**WEST SUSSEX COUNTY COUNCIL
FLOOD RISK MANAGEMENT CONSULTATION**

DATE: 29th October 2019

PLANNING REFERENCE: Y/83/19/OUT

LOCATION: Clays Farm, North End Road, Yapton, BN18 0DT

**Proposed Indicative Storm Water
and Foul Drainage Plan**

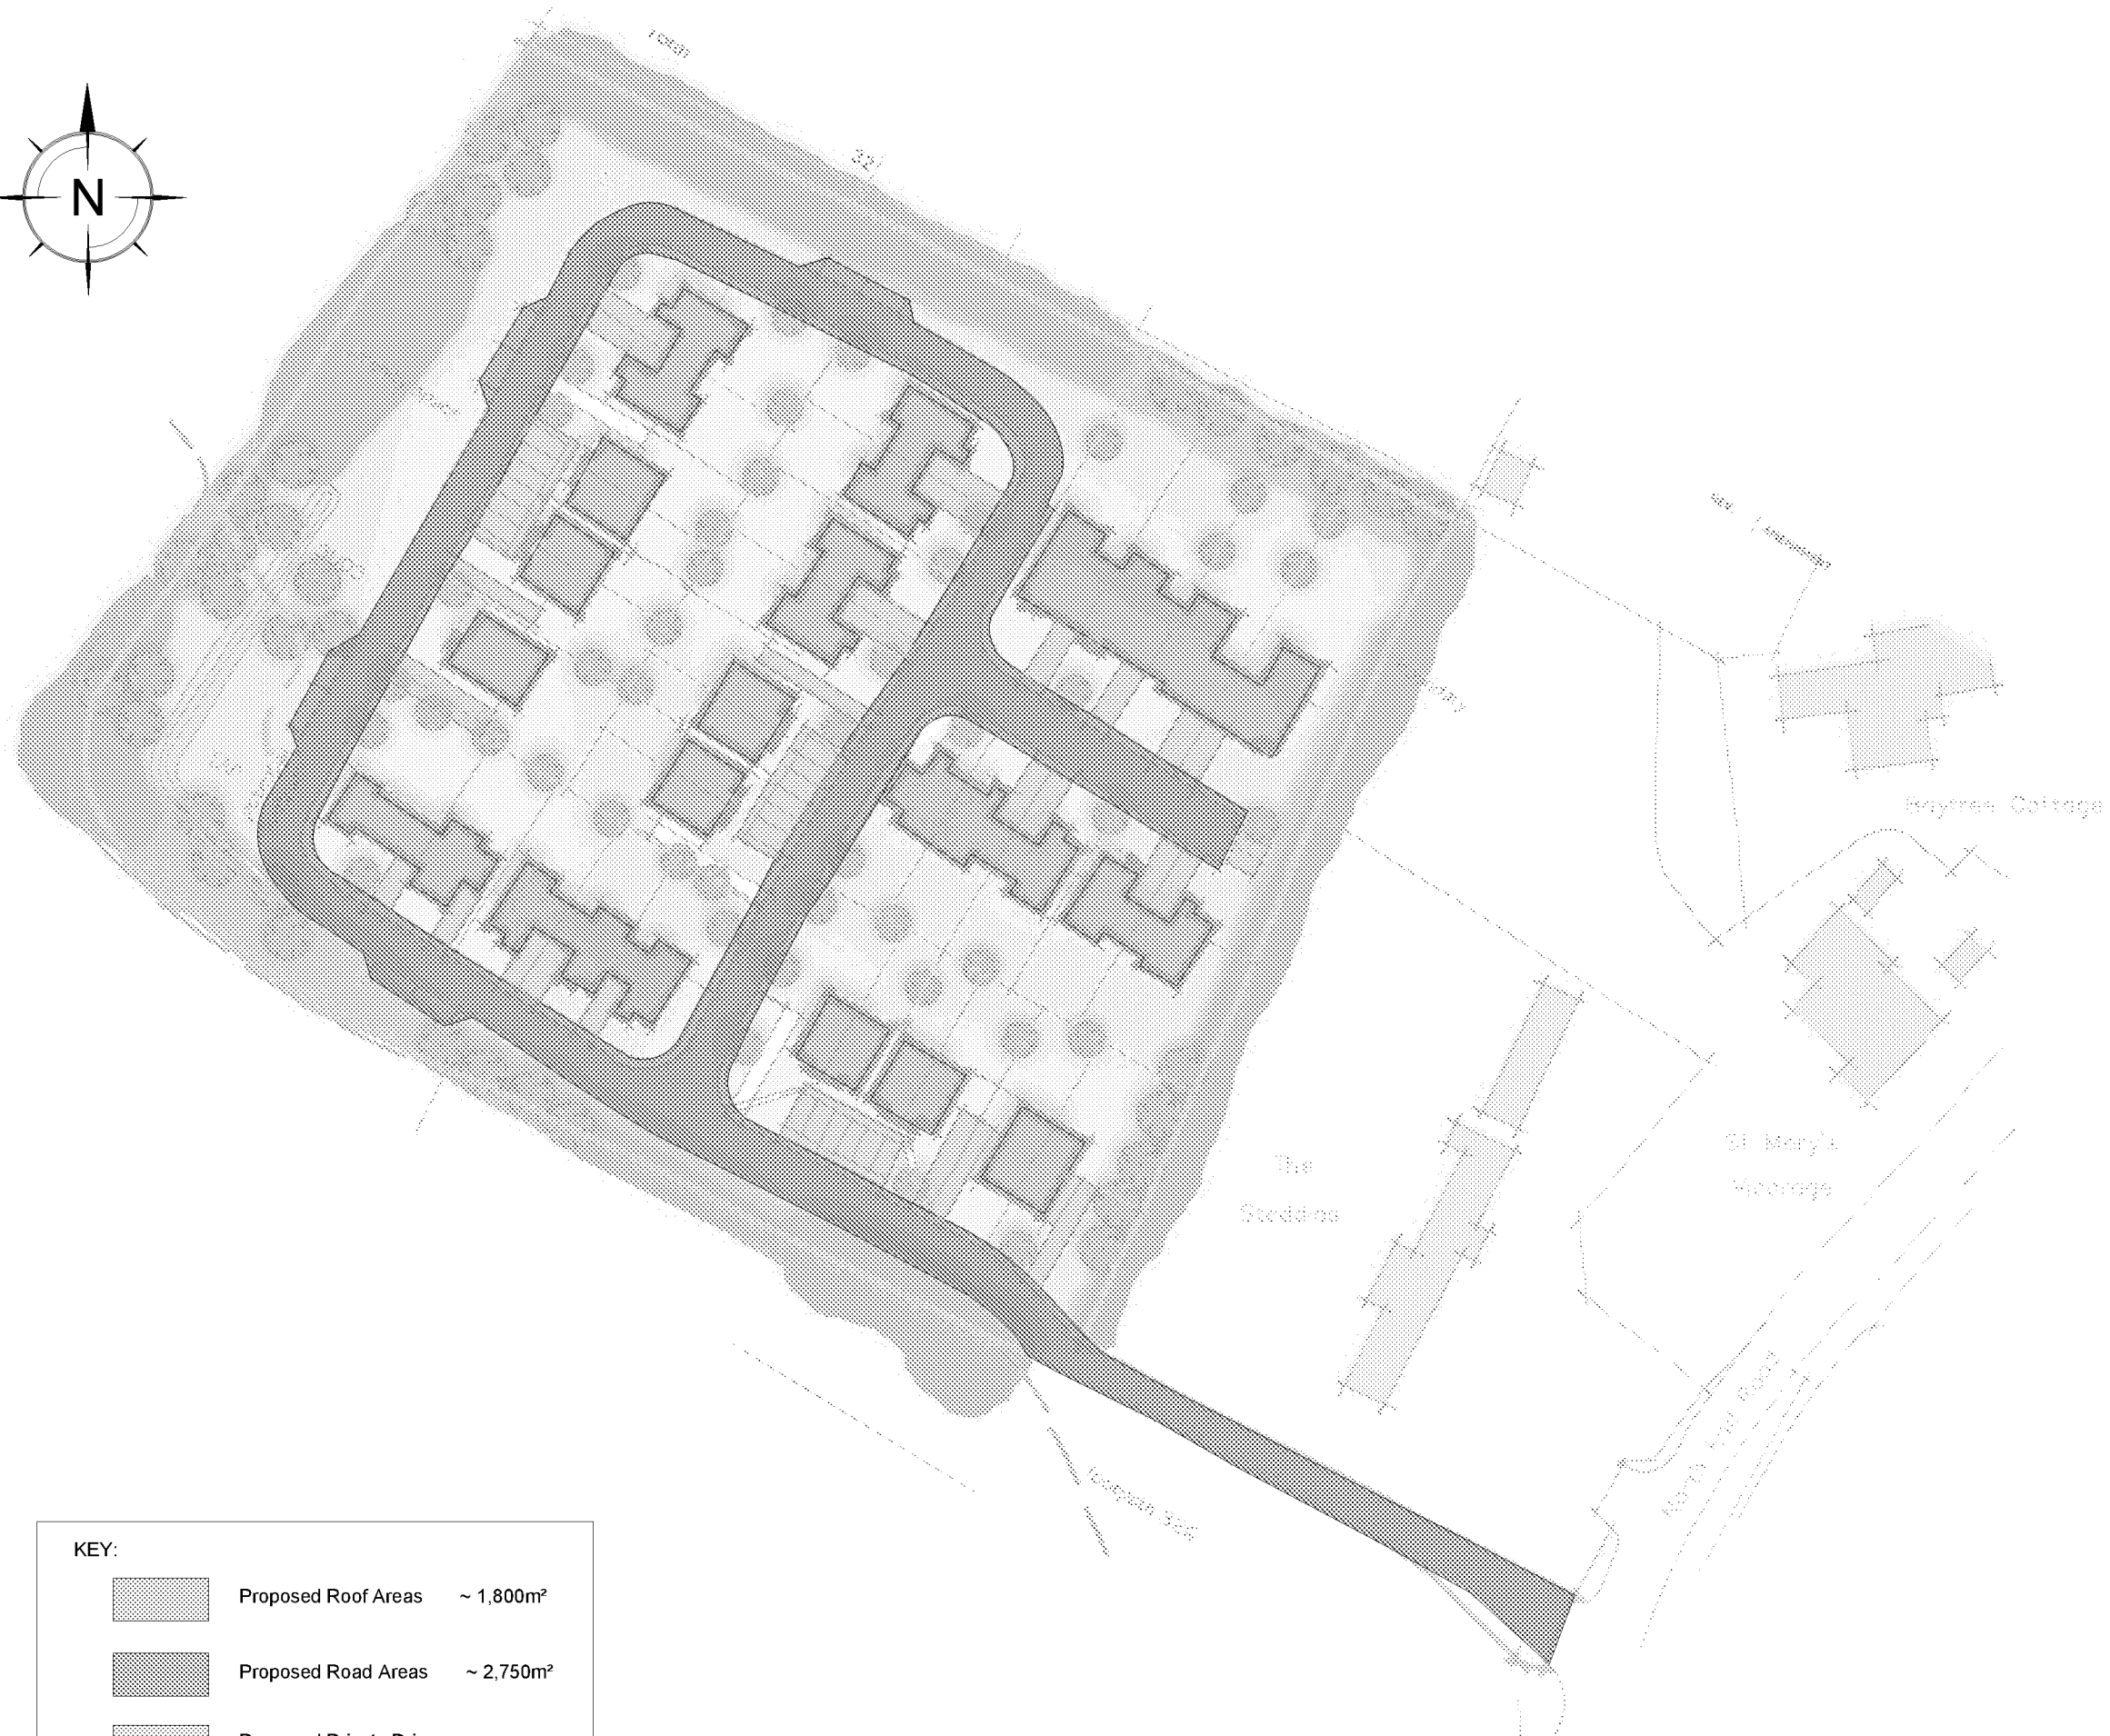
The Drainage and Maintenance Statement included with this outline application proposes that permeable paving, swales, bio retention units, rain gardens and soakways would be used to control the surface water runoff from the site.

As indicated by the ADC Drainage Engineer, winter groundwater monitoring should be carried out to assess how and where infiltration will be incorporated into the surface water drainage designs.

Development should not commence until finalised detailed surface water drainage designs and calculations for the site, based on sustainable drainage principles, for the development have been submitted to and approved in writing by the Local Planning Authority. The drainage designs should demonstrate that the surface water runoff generated up to and including the 100 year, plus climate change, critical storm will not exceed the run-off from the current site following the corresponding rainfall event.
